**Re: Veterans Integration Center at 2701 Mulberry St SE.
Erosion and Sediment Control Plan Sheets ESC-1, ESC-2, and ESC-3
Engineer's Stamp Date 5/9/23 (M15E054)**

Based upon the information provided in your submittal received 5/10/23, the above-referenced ESC Plan still cannot be approved for Building Permit until the following additional information is provided.

ESC-1

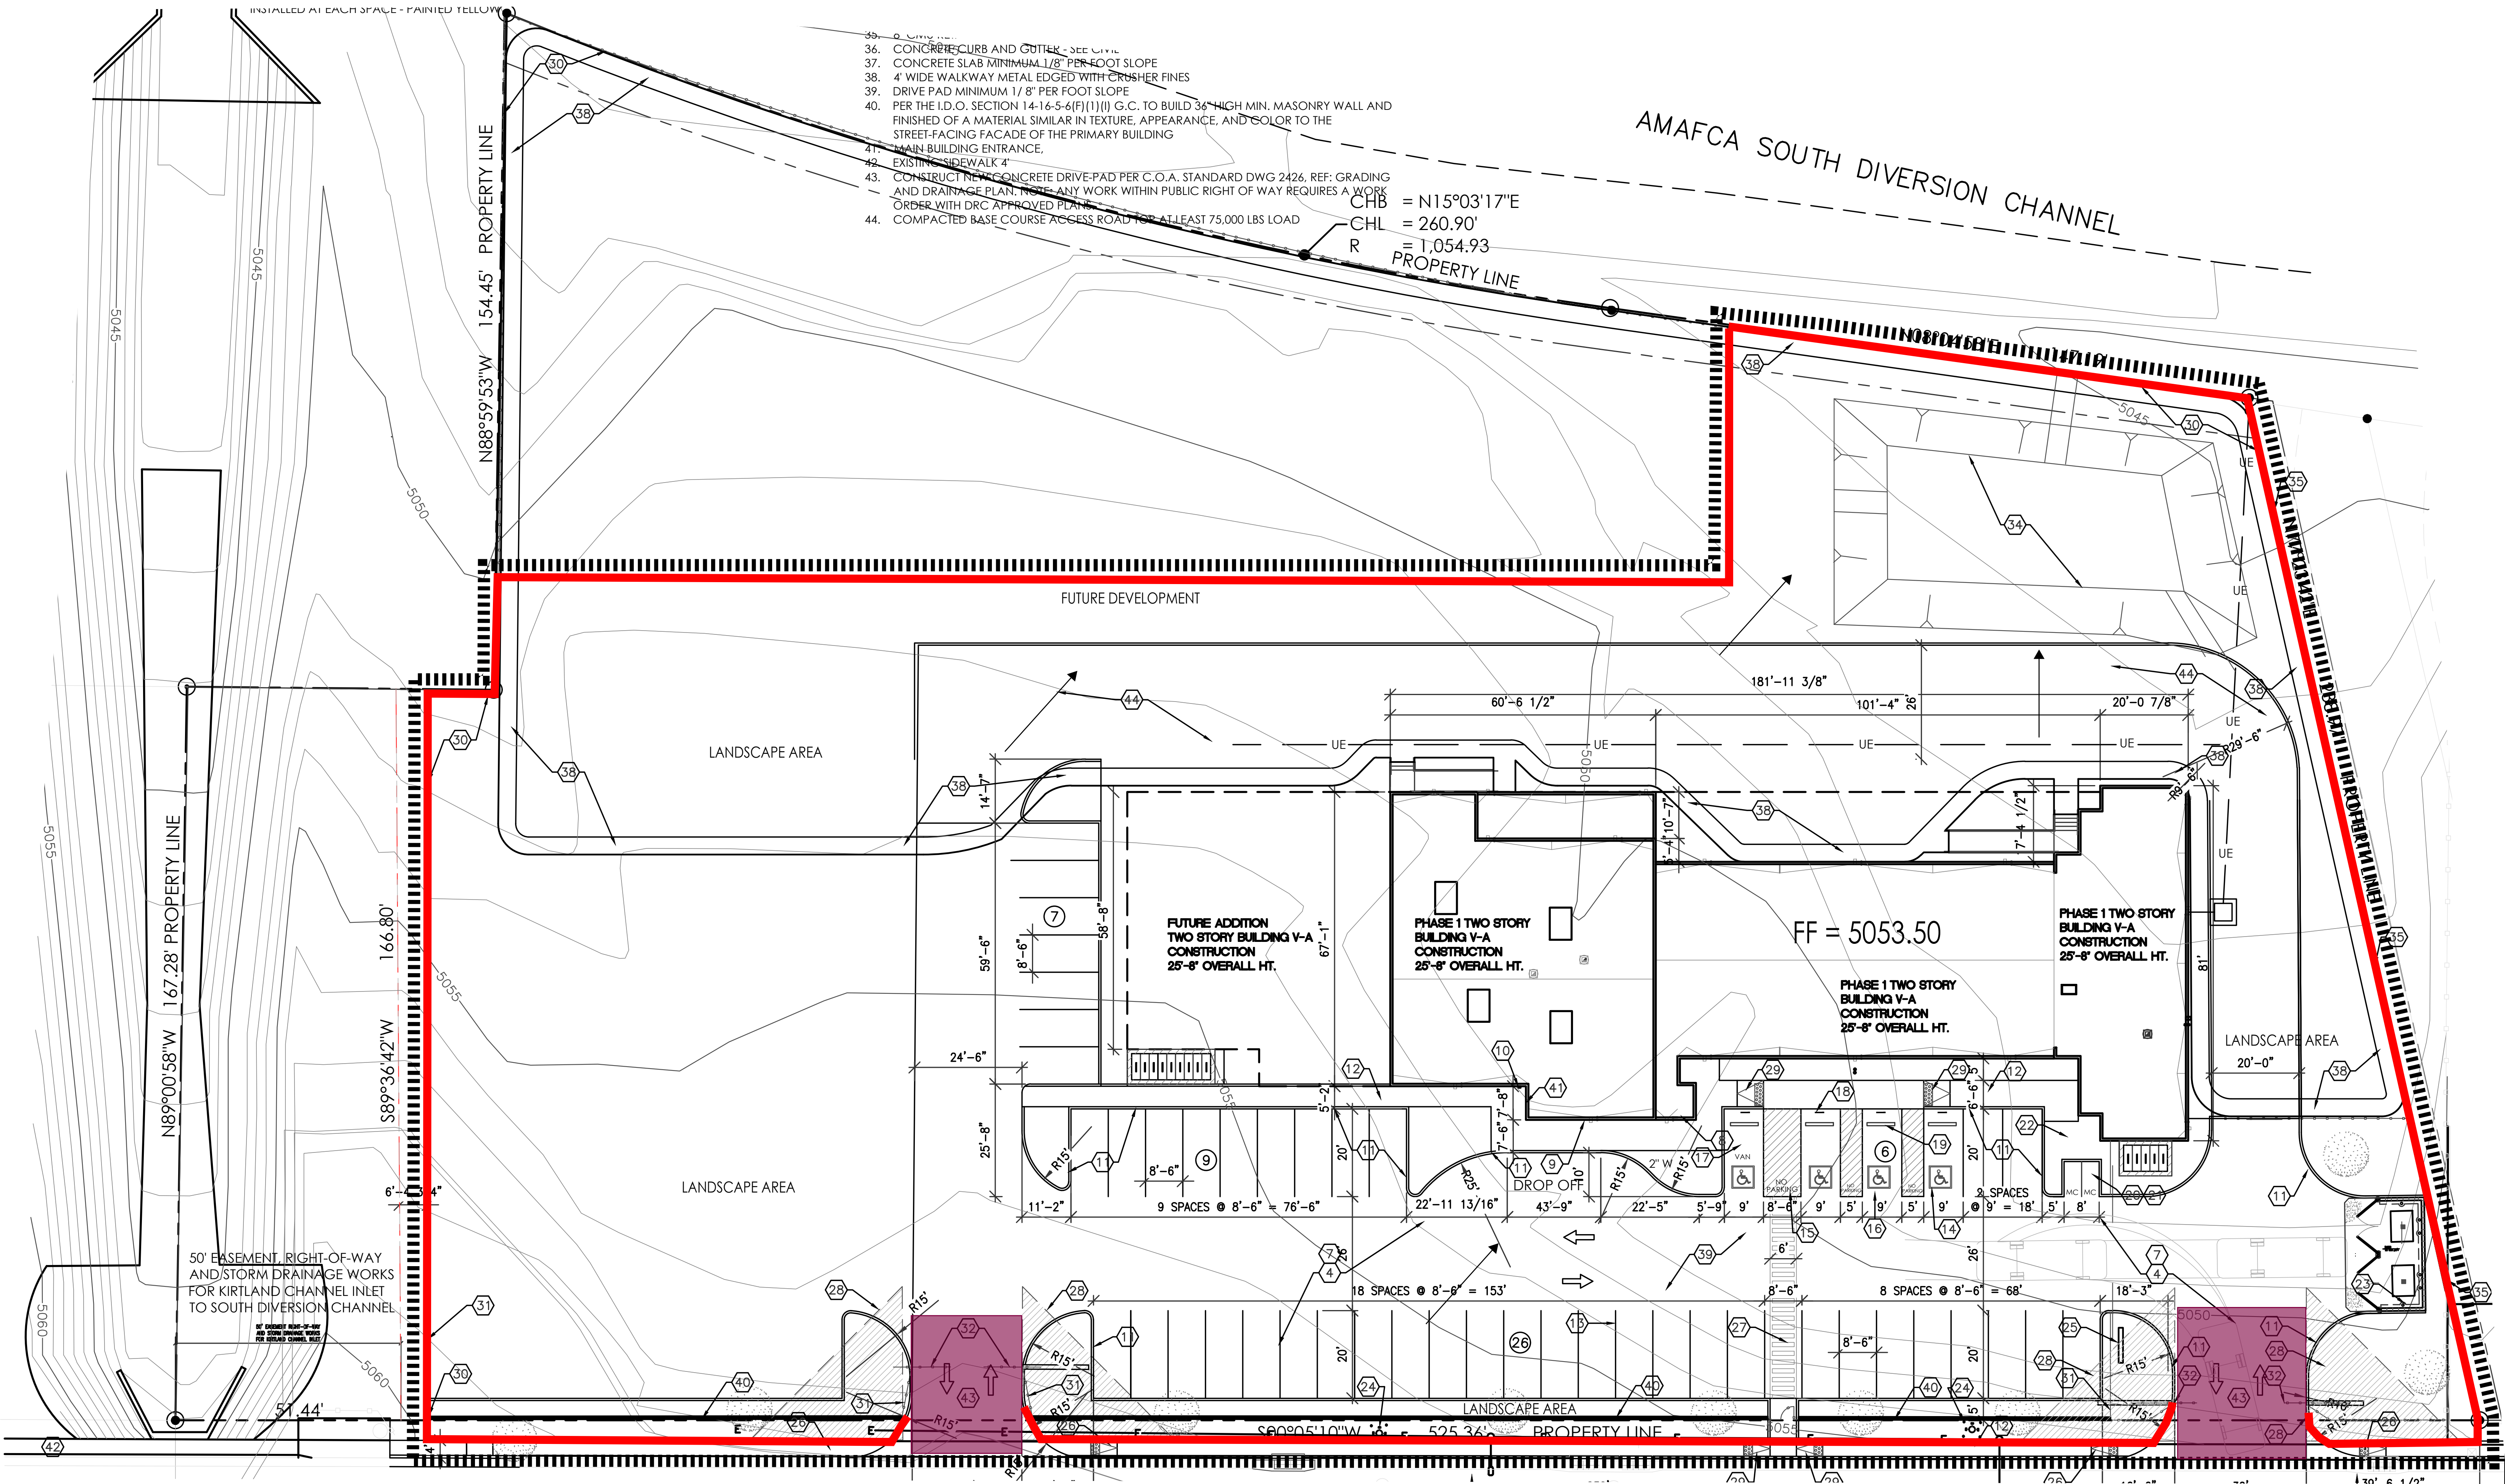
1. The note in the top right corner of sheet ESC-1 provides the specific vegetative practice that will be used, but seems to limit its application to areas of new disturbance, omitting the area that was disturbed by the previous property owner. The limits of disturbance don't encompass the existing disturbed area. The limits of disturbance and silt fence must be located farther to the west to encompass the existing disturbed area. The note must be revised to replace the words "Any areas disturbed during construction of phase 1" with "All disturbed areas". Per CGP 7.2.6.b.vi, include the following:
 - a) The stabilization deadline that will be met in accordance with Part 2.2.14.a.i-ii;
 - b) The beginning and ending dates of the seasonally dry period and the schedule you will follow for initiating and completing vegetative stabilization.

Also add a note in the top right corner of sheet ESC-1 that says "Seed and hydromulch will not satisfy the EPA's Final Stabilization Criteria (CGP 2.2.14.c) until perineal vegetation is established, which may take a long time. The Property Owner must continue permit coverage, self-inspections, SWPPP and BMP maintenance until the City determines that the Final Stabilization Criteria CGP2.2.14.c has been satisfied."

2. This new layout must be shown on a revised Grading Plan for approval by Hydrology. The finished grades must be shown on the ESC Plan and they must agree with the approved Grading Plan. The ESC Plan can't be approved until after the revised Grading Plan has been approved.
3. The phone number in the "Operator Point of Contact Information" on the NOI doesn't work, so the NOI must be revised.
